From: Gareth Rollings
Sent: 12 June 2015 09:09
To: Planning.Responses
Subject: RE: Planning Consultation on A/67/15/DOC

APPLICATION **A/67/15/DOC**
NO:

Site Address: Former Pound Nursery Roundstone Lane
 Angmering BN16 4AL

Description of Works: Application for approval of matters reserved by condition imposed under A/167/14/PL relating to conditions 3, 4, 6, 10, 11, 12, 13, 14, 15, 18, 20, 21, 22 & 23 for schedule of materials, tree protection, prevention of surface water drainage on highway, construction of roads, footways/casual parking areas, Travel Plan,

TITLE
Section 278 Agreement Plan

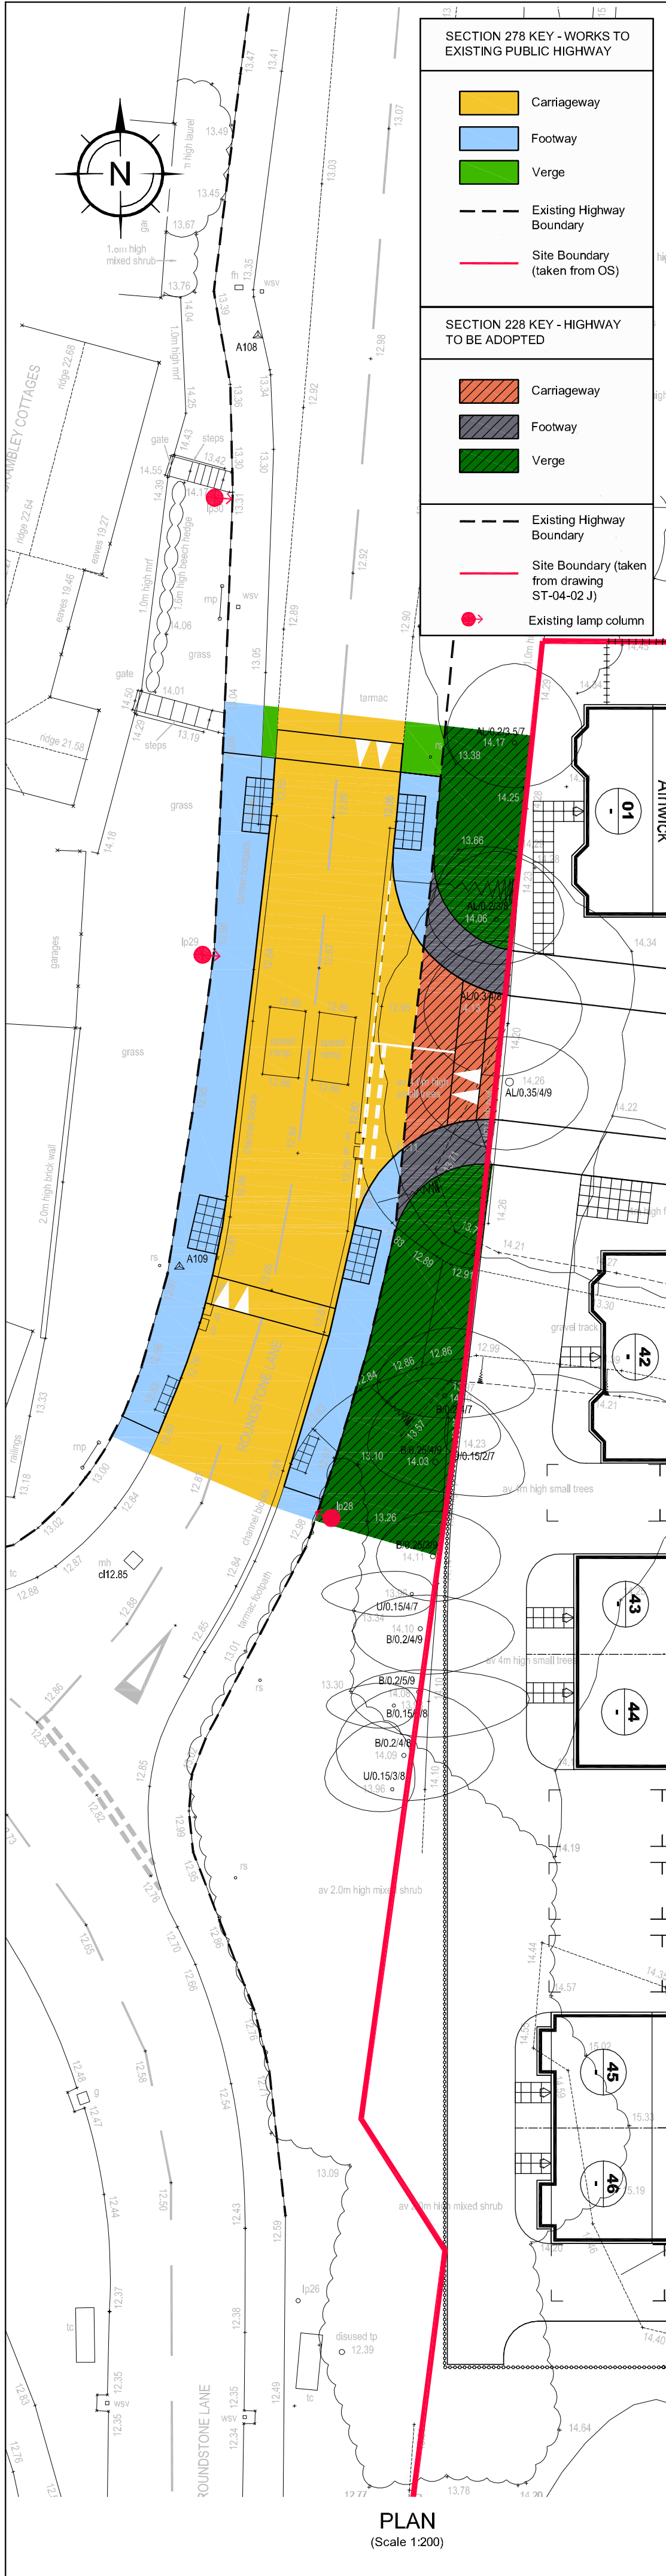
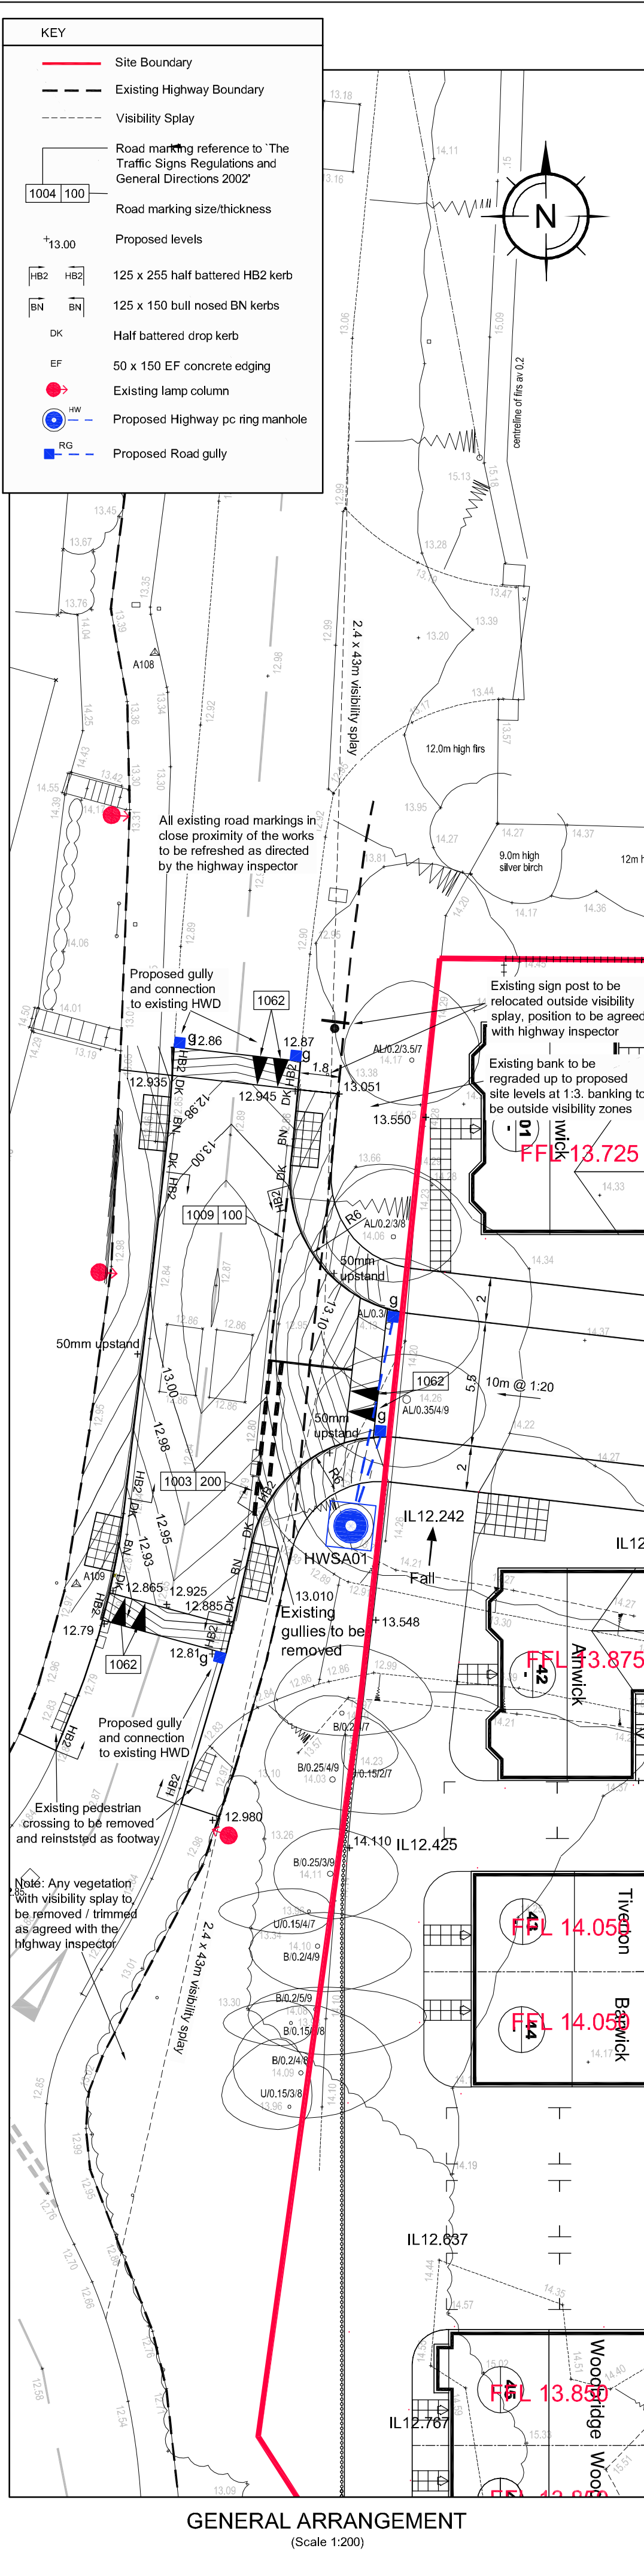
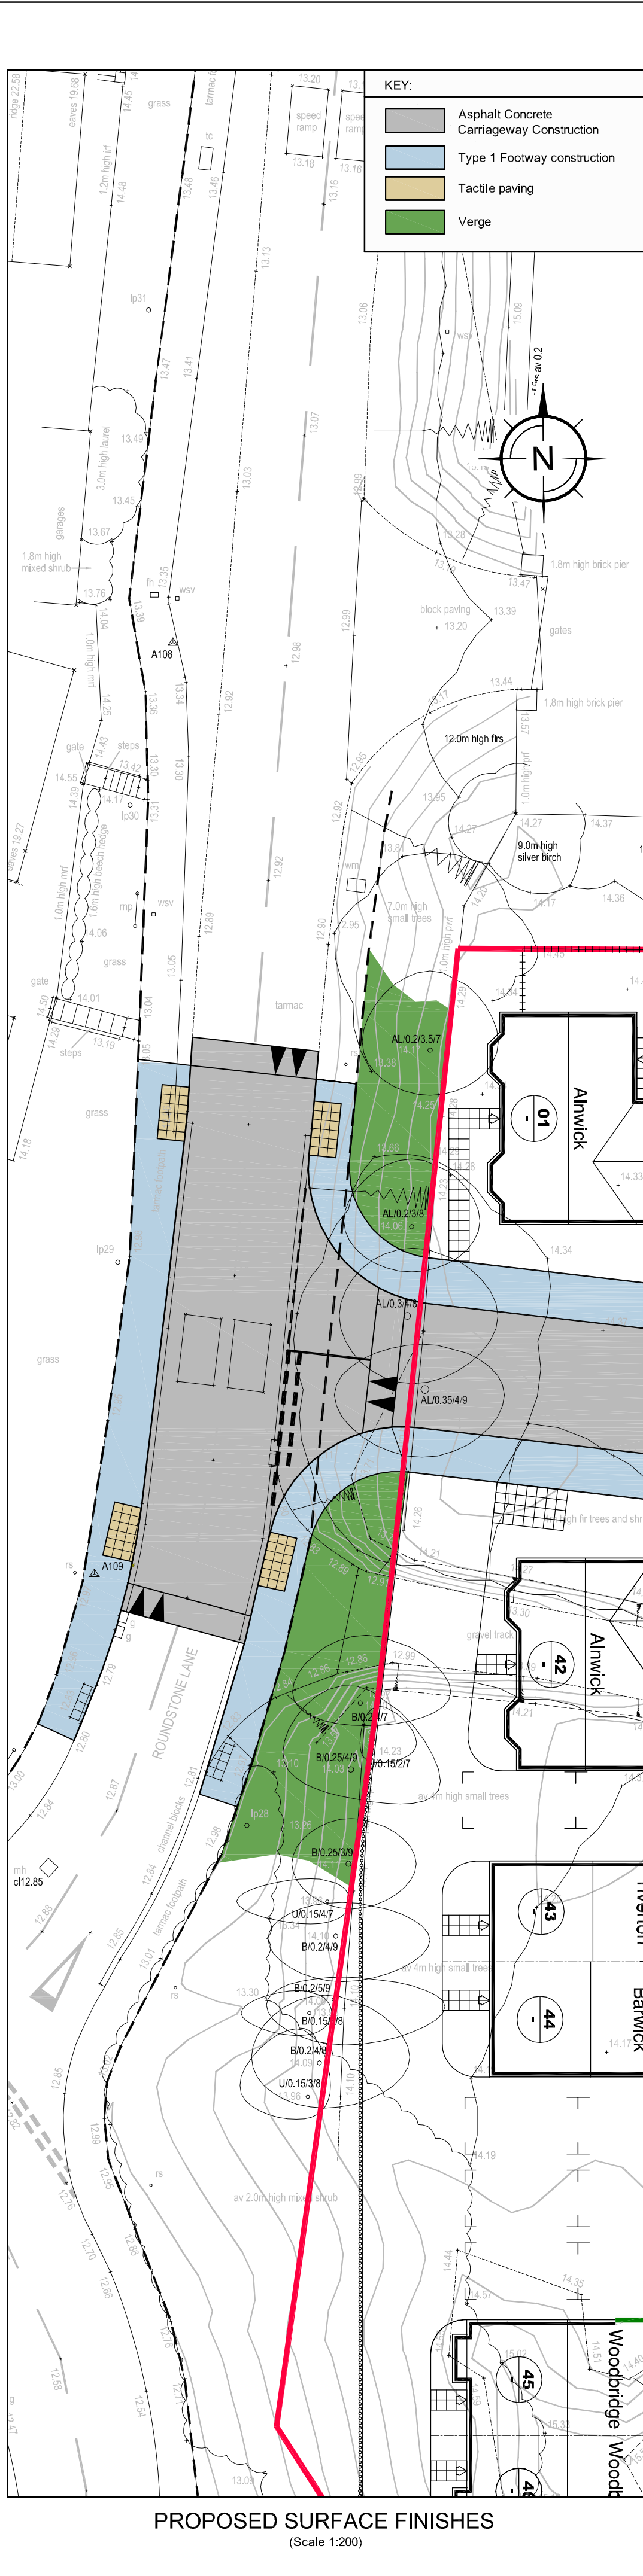
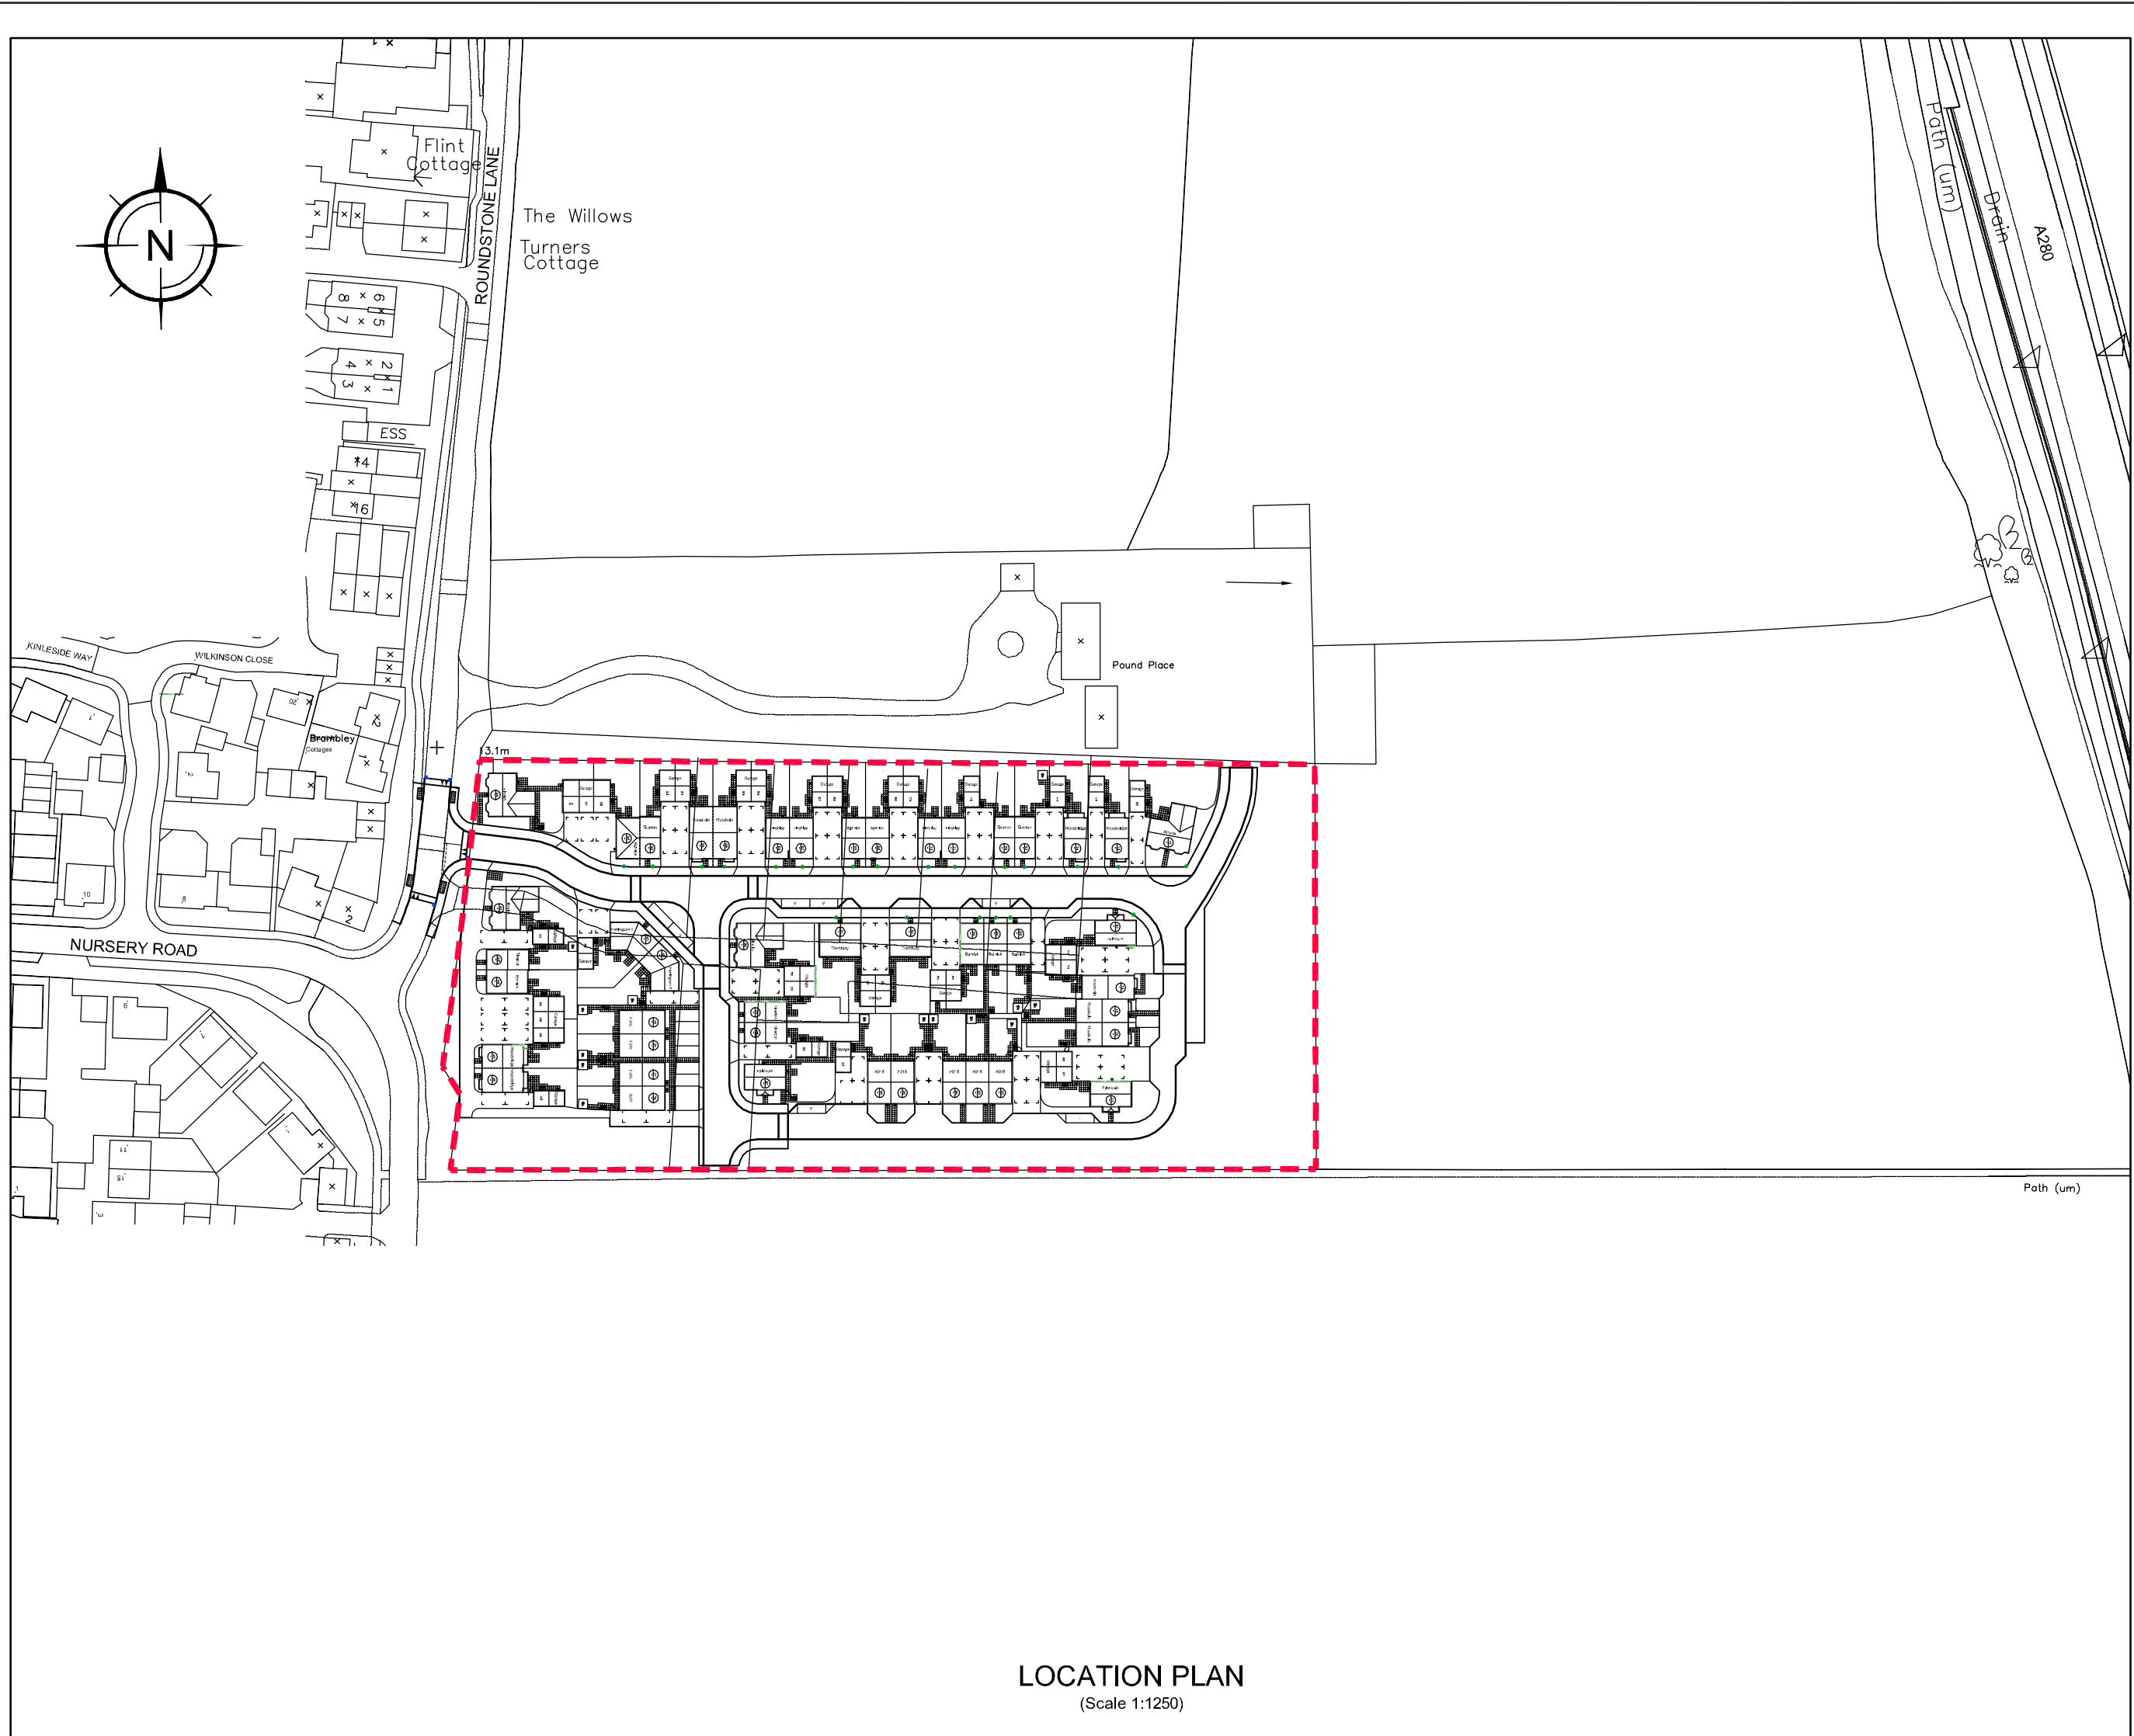
To empty bins outside of properties the vehicle will need to be able to drive down and stop outside each property, this looks quite tight on plots 21-26, if the vehicle is not able to stop at each property the residents will need to bring all waste down to a location that can be stopped at by the waste vehicles. As a rough guide the below should be worked too:

1. Roads must be of sound construction, to a suitable hard surface free of potholes and obstructions.
2. The road must be not less than 3 metres wide, with no obstructions from overhanging trees or shrubs etc.
3. There must be a minimum of 5.5 metres height clearance with no obstructions from overhanging branches or cables.
4. When a through road does not exist, a turning area must exist. A 10.22 metre long vehicle must be able to turn around in 3 manoeuvres or less.
